Please ask for: Ms Iqraa Malik
Email: iqraa.malik@terraquest.co.uk
Telephone: 0121 234 1390
Our Ref: WA/104/21/HH
Your Ref:
Date: 8th November 2021

Application for Planning Permission for Works or Extension to a Dwelling

Development: Two storey side extension, two storey other side extension, single storey porch extension following demolition of existing conservatory, garage and porch.
Location: Woodend Cottage Copse Lane Walberton BN18 0QH

Drawing Details	
Existing Site Plan PLANNING ISSUE	
Drawing No. C0215-P001	Date October 2021
Scale ISSUED 1:1250 @ A3	Revision A

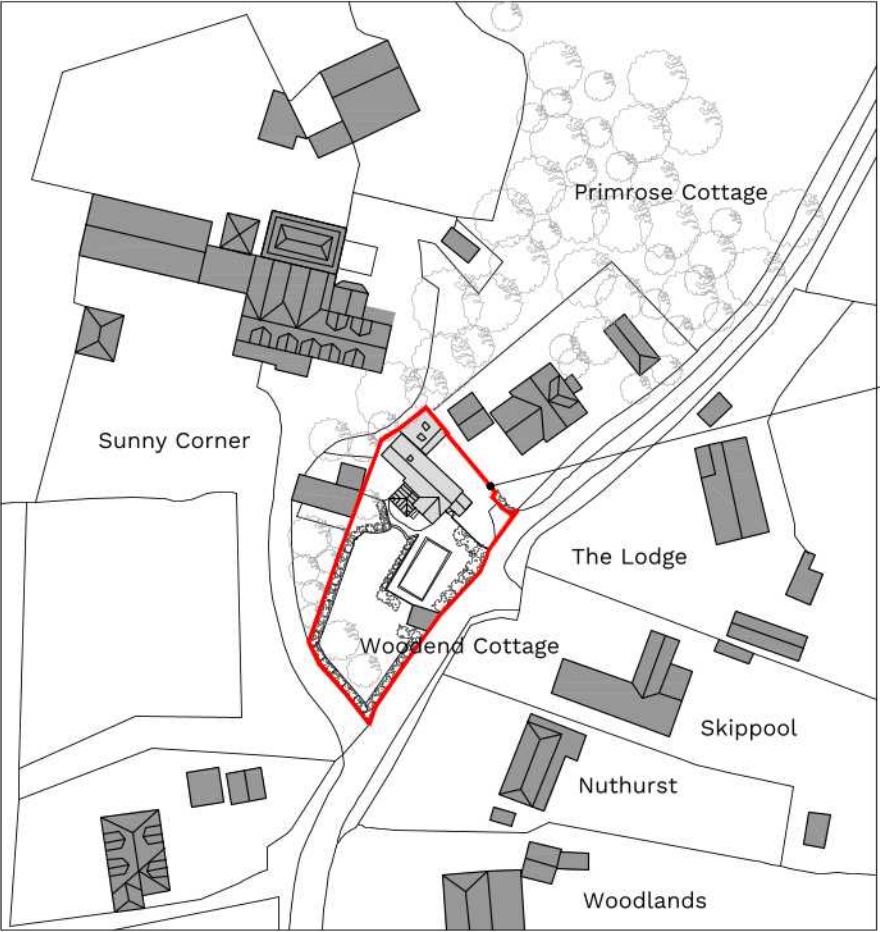
Location Plan

The location plan scaled 1:1250 must have a solid red outline, please amend. Further details of what must be included on the plan can be found in the Validation Requirements List.
